DELEGATED DETAILS DECISION

Report of the Head of Planning, Building Control, Sport & Green Spaces

Address GOLDEN CROSS BOTWELL LANE HAYES

LBH Ref Nos: **4607/APP/2014/3648**

Soft Landscaping

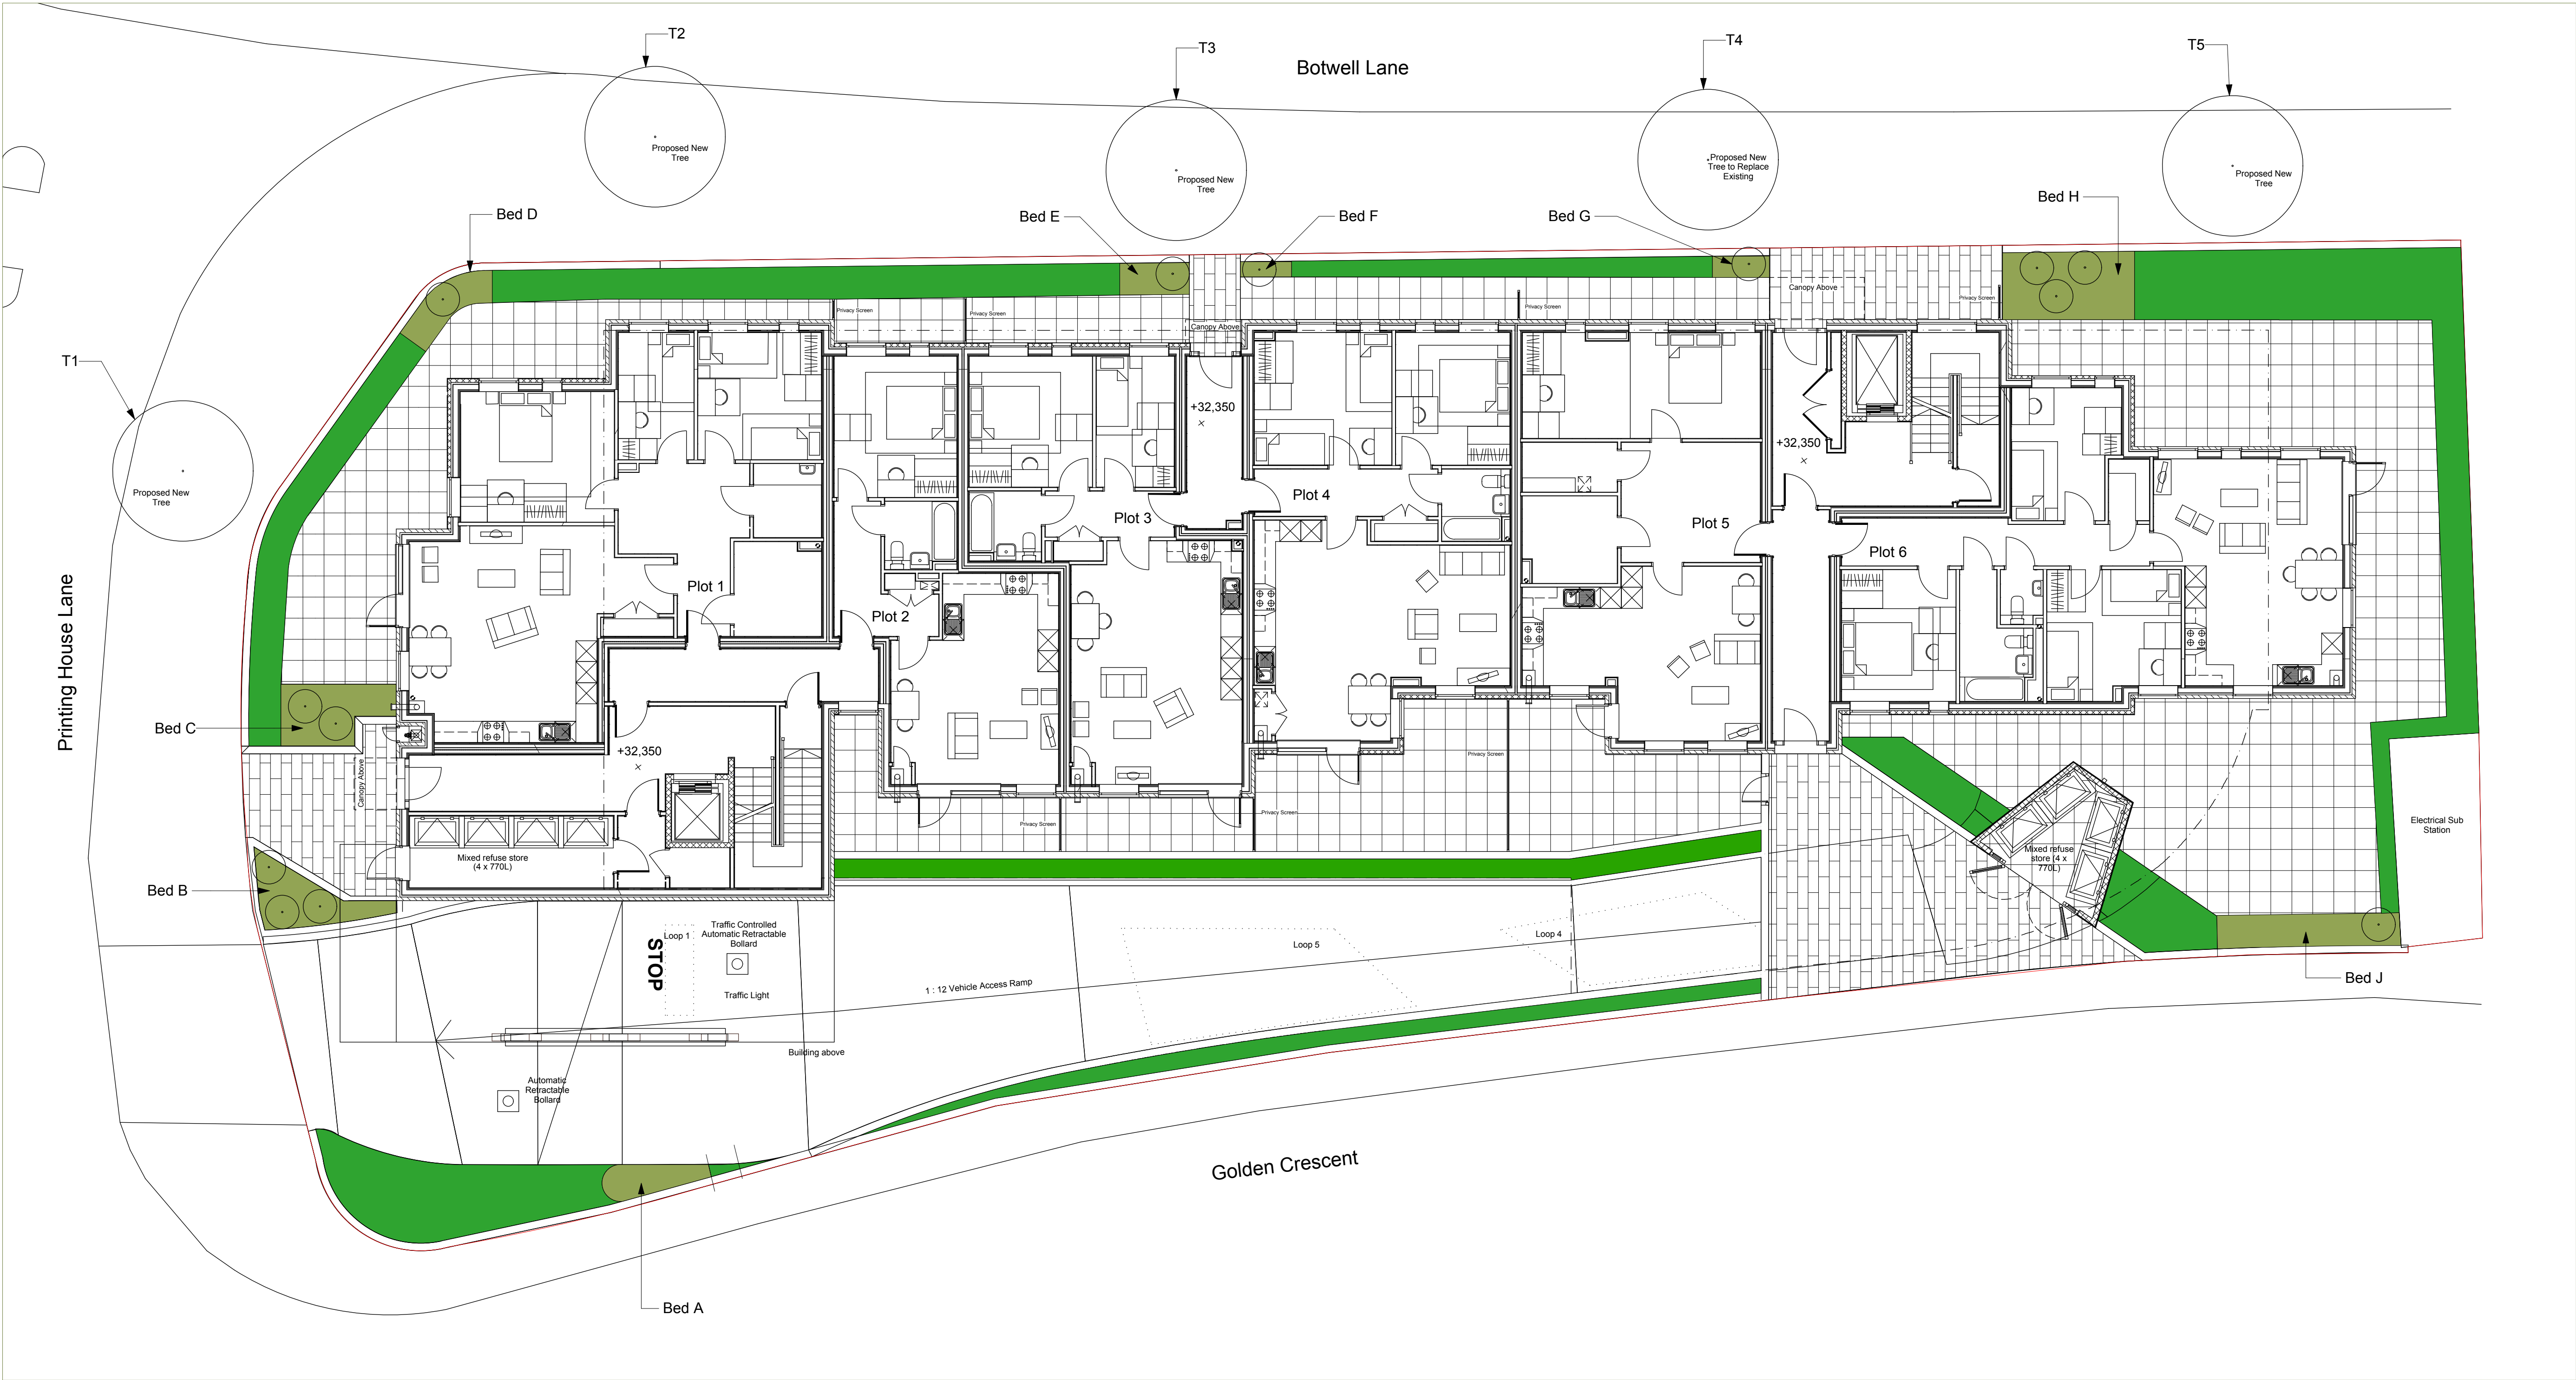
Garden House Design drawing No. GHD2058 Rev C, Soft Landscaping, provides

a planting plan for the site consisting of narrow strips of grass around the perimeters and generally low-growing groundcover shrubs and perennial plants. The grass strips will be impracticable to use or maintain. The overall effect will provide no spatial definition or privacy and contribute little to the visual amenity of the area.

- The proposed planting will barely register on this site. The planting blocks are too small and the selected plants too low.
- There is insufficient space to accommodate grass on this tight site. Grass will be of little/no benefit to residents and impracticable to maintain.
- Hedges (of a reasonable size on day one) should be specified for all boundaries. They should be grown to, and maintained at, a specified height which should provide some privacy/screening for the residents at ground floor level.
- Further vertical interest should be provided by tree planting at strategic points - for example where the key specifies 'soft landscaping'.
